**From:** Jeff Tarling  
**To:** Jean Fraser  
**CC:** David Margolis-Pineo  
**Date:** 1/22/2014 2:49 PM  
**Subject:** 118 Congress Street Project

118 Congress Street project / tree & landscape review comments:

Tree & Landscape review comments for the proposed 118 Congress Street project:

7  
L2.0  
NOT TO SCALE  
EXISTING TREE PROTECTIVE FENCING (FOR PIN OAK)

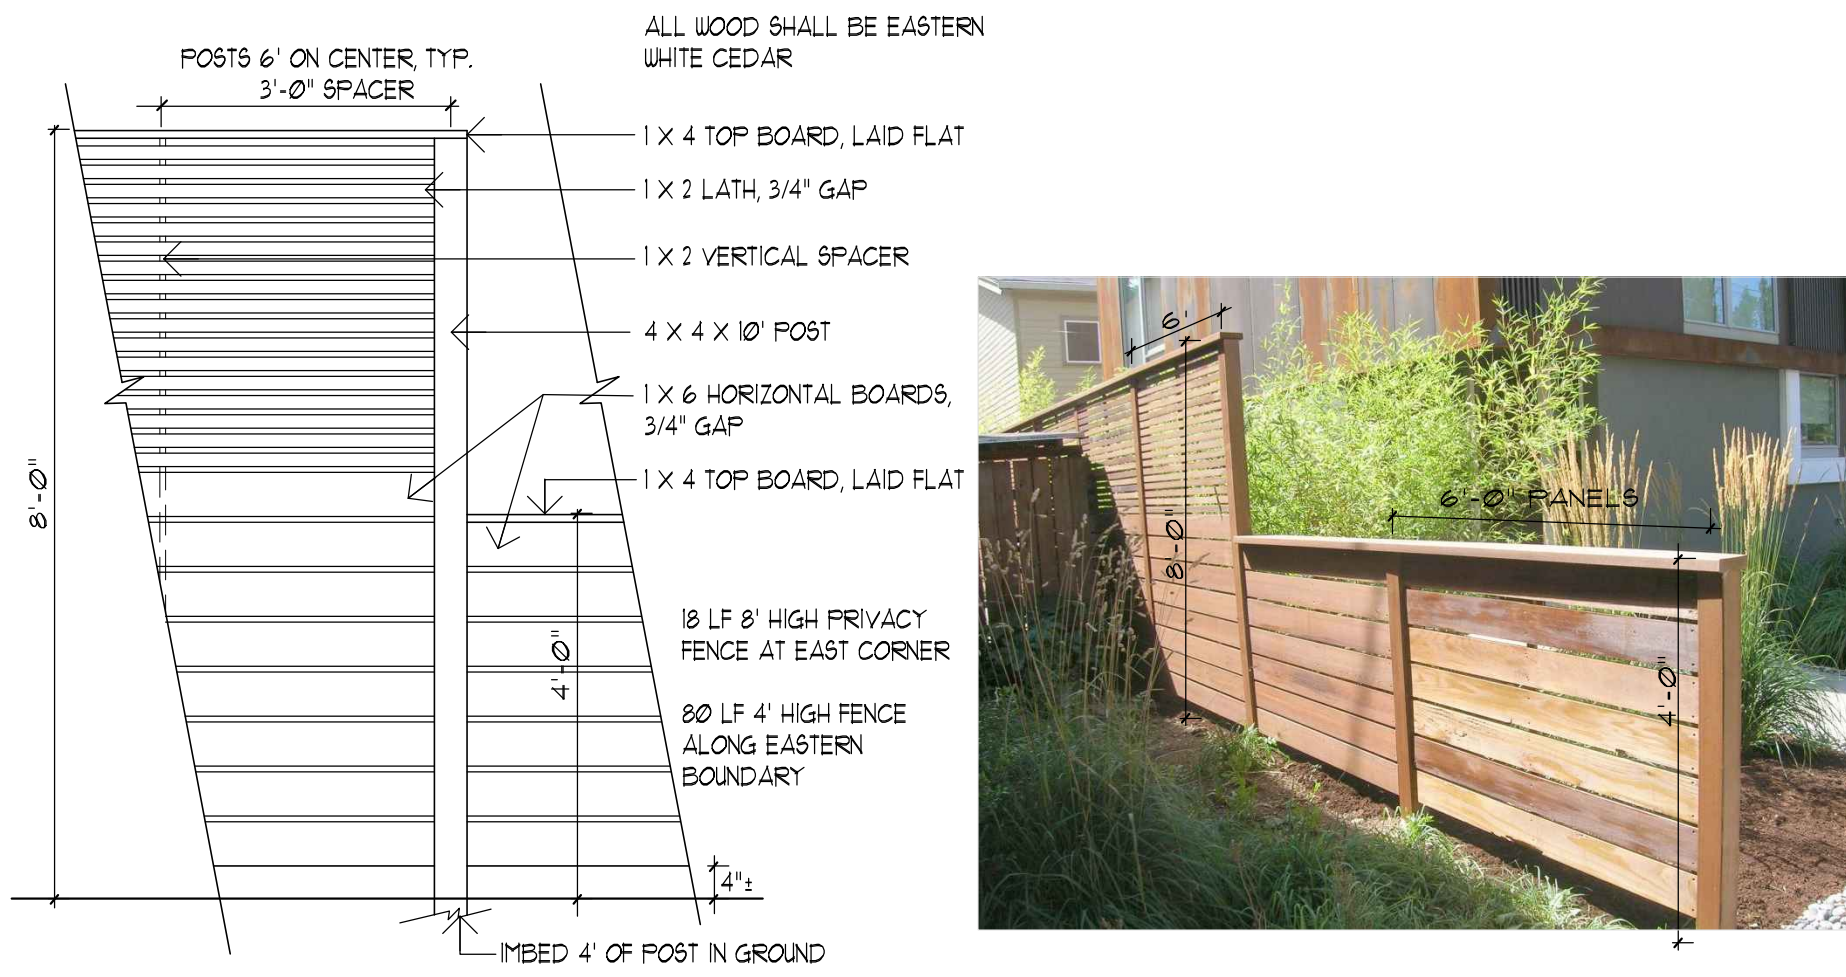
**'Tree Save'** - I was hoping the project could protect or save the large Pin Oak on Saint Lawrence Street, while the recent plan does show this, a recent site visit confirmed the crown of the tree would be severely impacted or one-sided, thus reluctantly yield to the fate of removal due to proposed building location. An additional street tree would be requested. Also, the proposed new tree on Congress Street near the corner of Saint Lawrence should be shifted slightly away from the intersection perhaps 2 - 3'. The recently planted American Elm along Congress Street should be saved and replanted by the city.

5  
L2.0  
NOT TO SCALE  
RAISED GRANITE PLANTER - ISOMETRIC VIEW (AT CURB RAMP ON CONGRESS STREET)

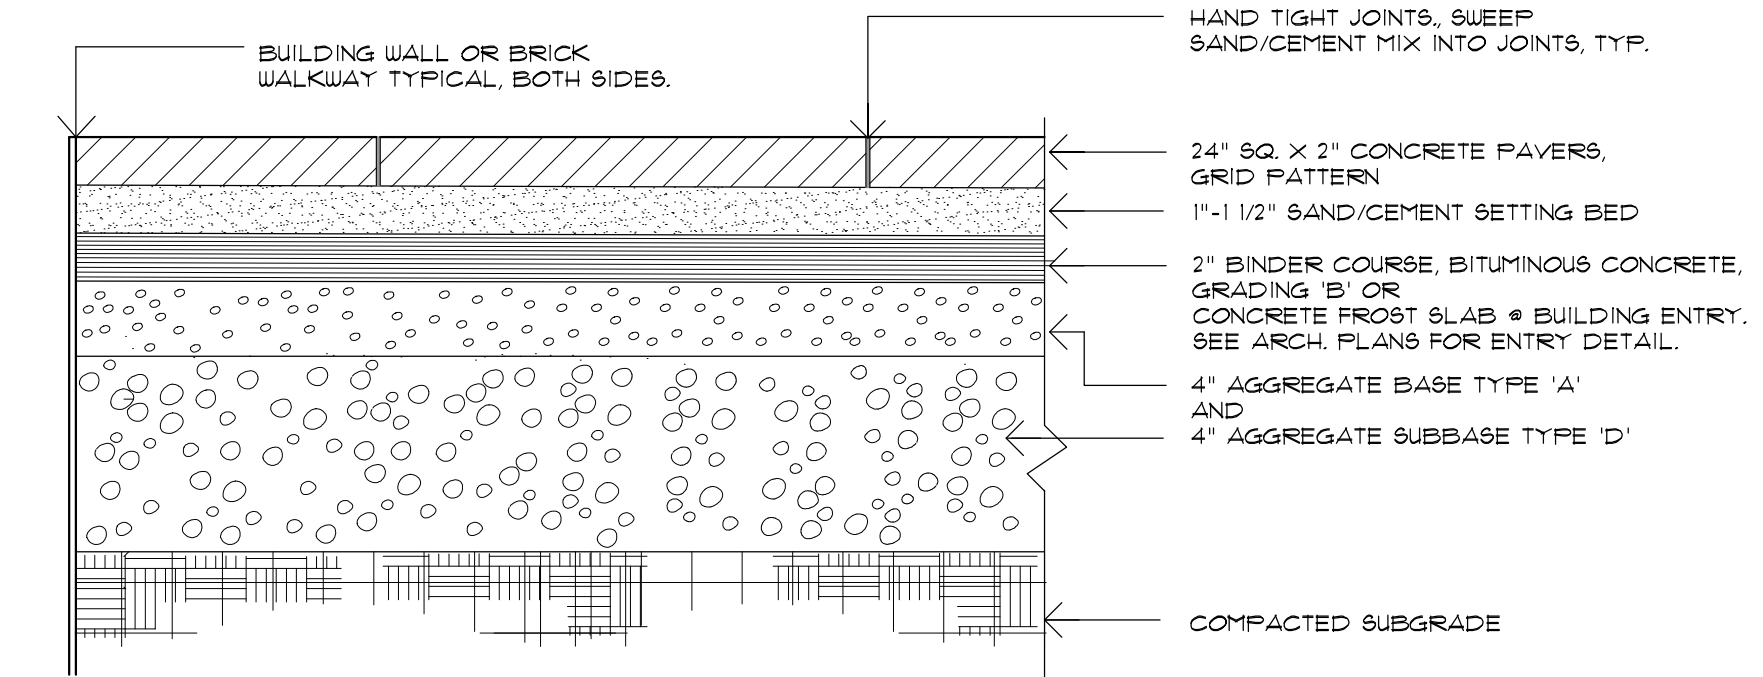
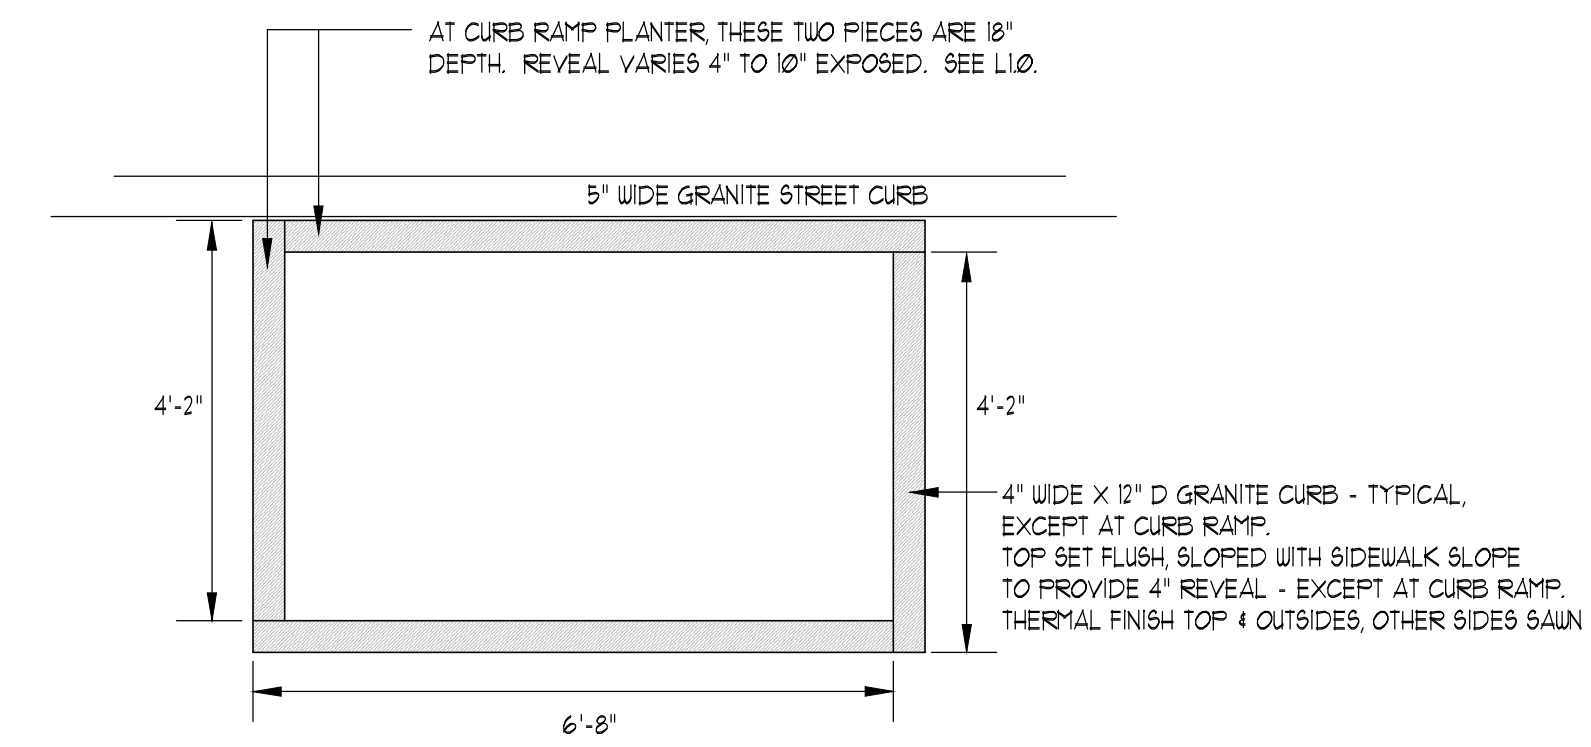
**Granite planters in right of way** - the six granite planters are proposed to be planted with street-trees and 'Cranesbill', perennial geranium. This will add interest to the typical mulched tree well. Long term however it is unlikely the city would be able to maintain these plantings. Ideally, the project could adopt the tree wells and maintain the landscape planting.
